Our Ref: R/15/19/HH

**Town & Country Planning Act 1990 (as amended)
Town & country Planning (Development Management Procedure) (England) Order 2015
Application for Planning Permission for Works or Extension to a Dwelling**

Development Convert existing garage to habitable space, new oriel window replacing existing, render to existing brick frontage & part side walls & replacement of flat roof with pitched tiled roof.

Location 28 The Crescent Rustington

Drawing: FLOOR PLAN - AS PROPOSED

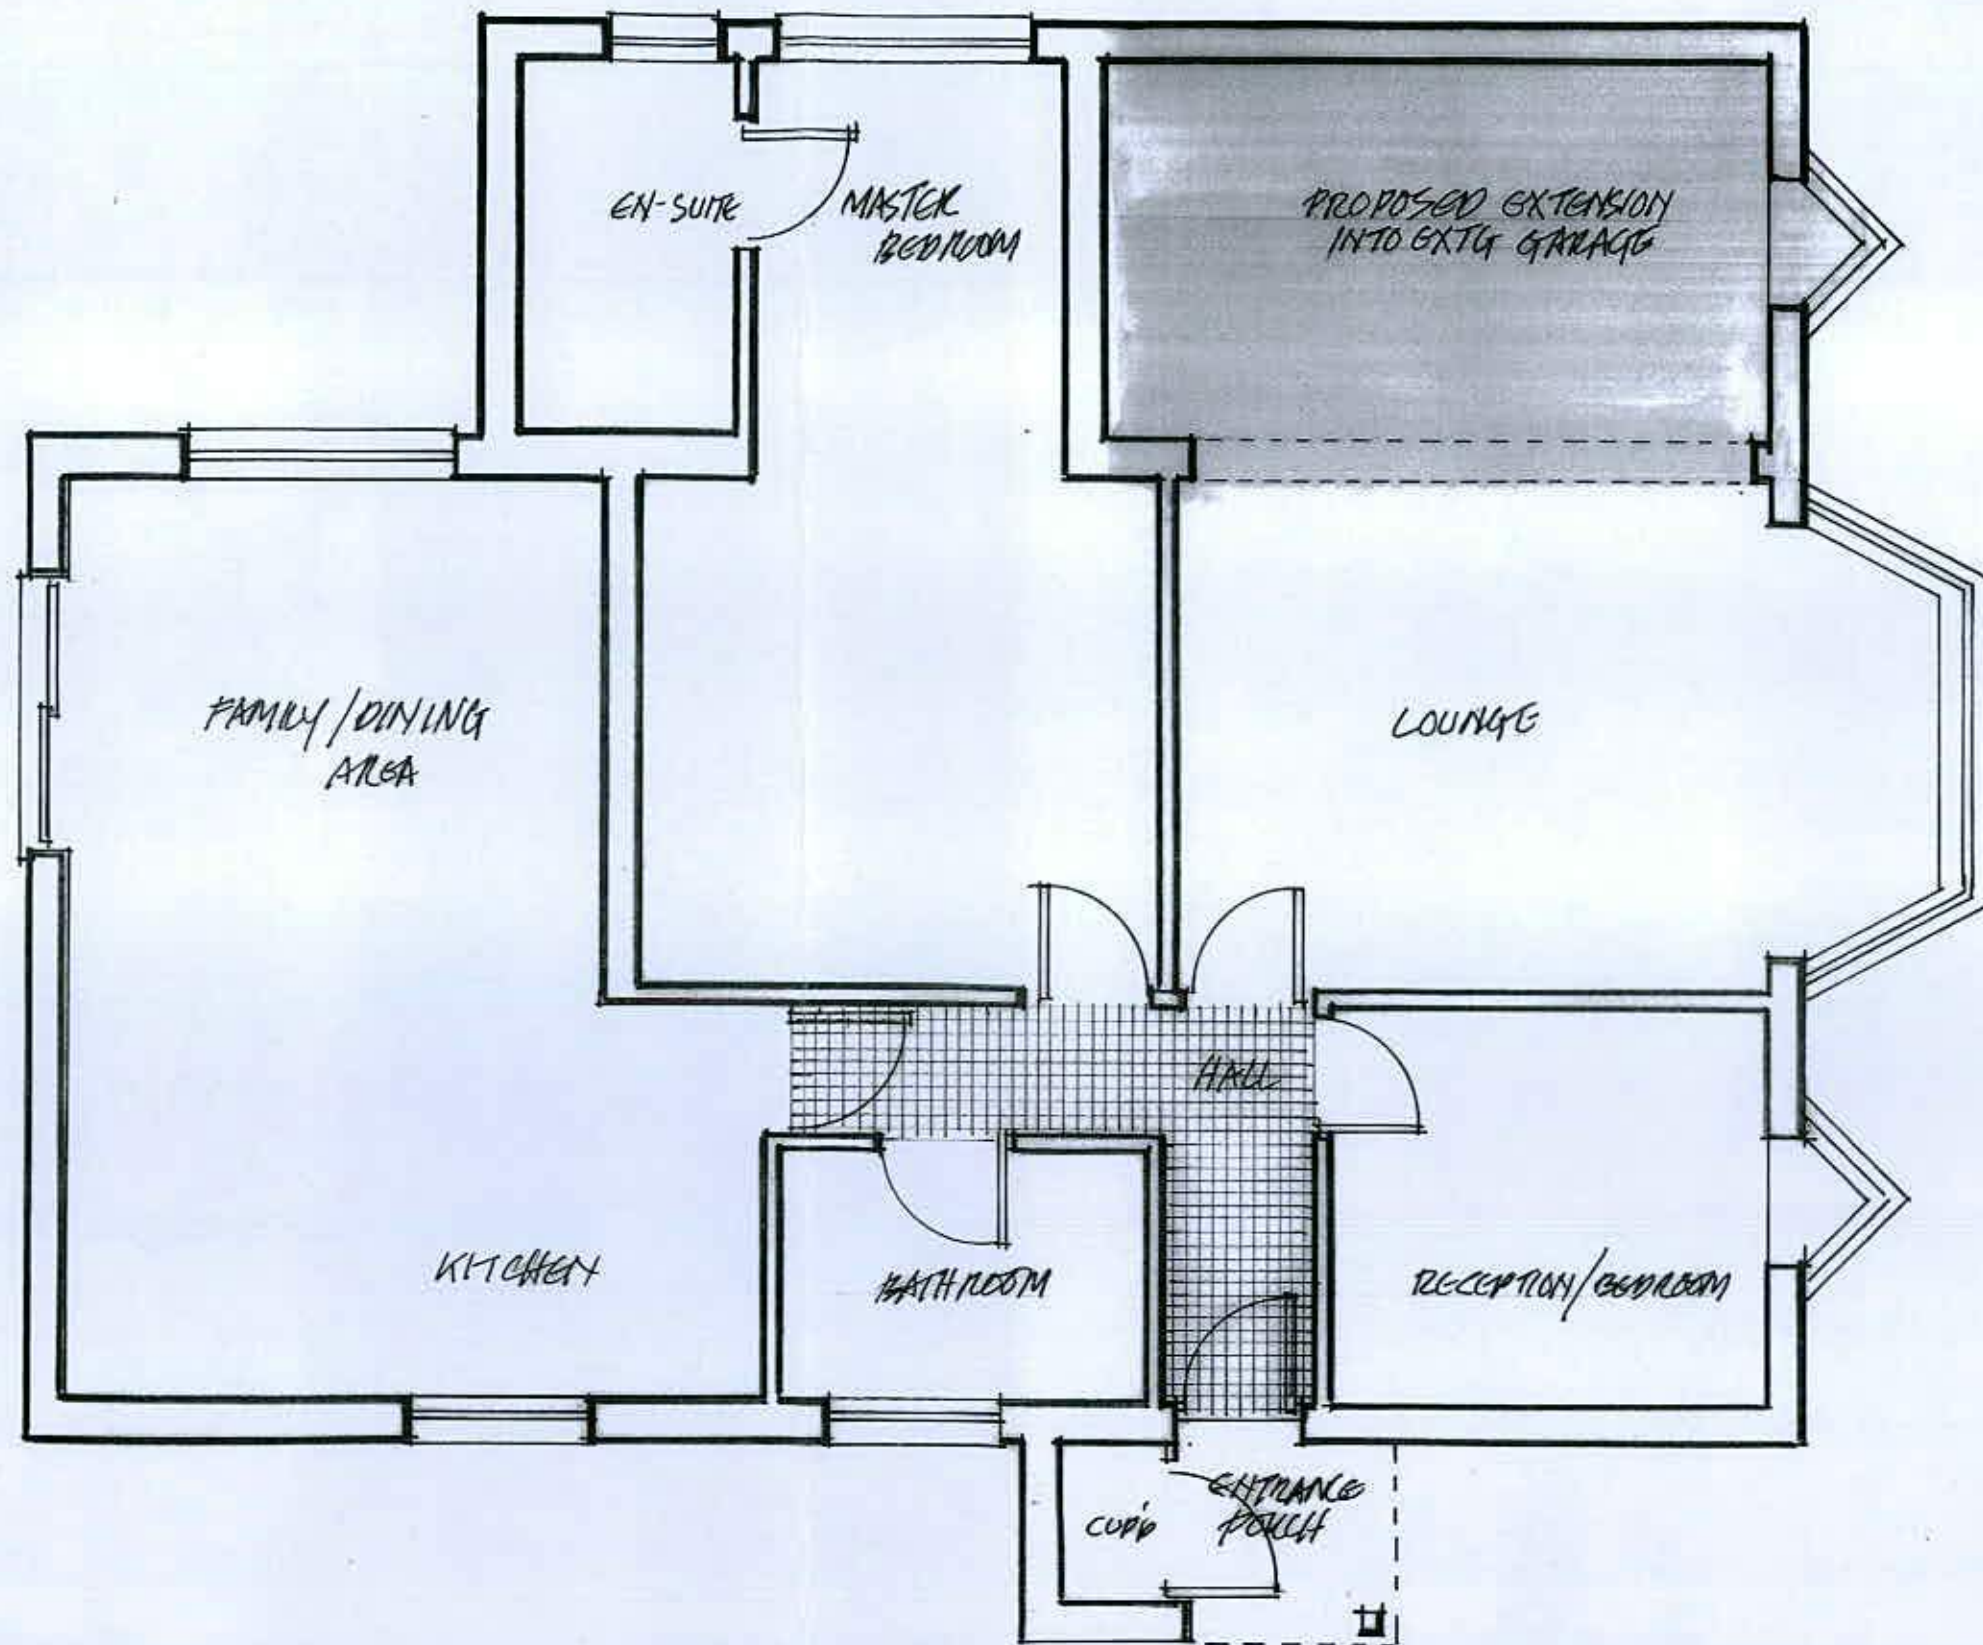
The existing and proposed west elevations and floor plans do not accord. Please amend accordingly.
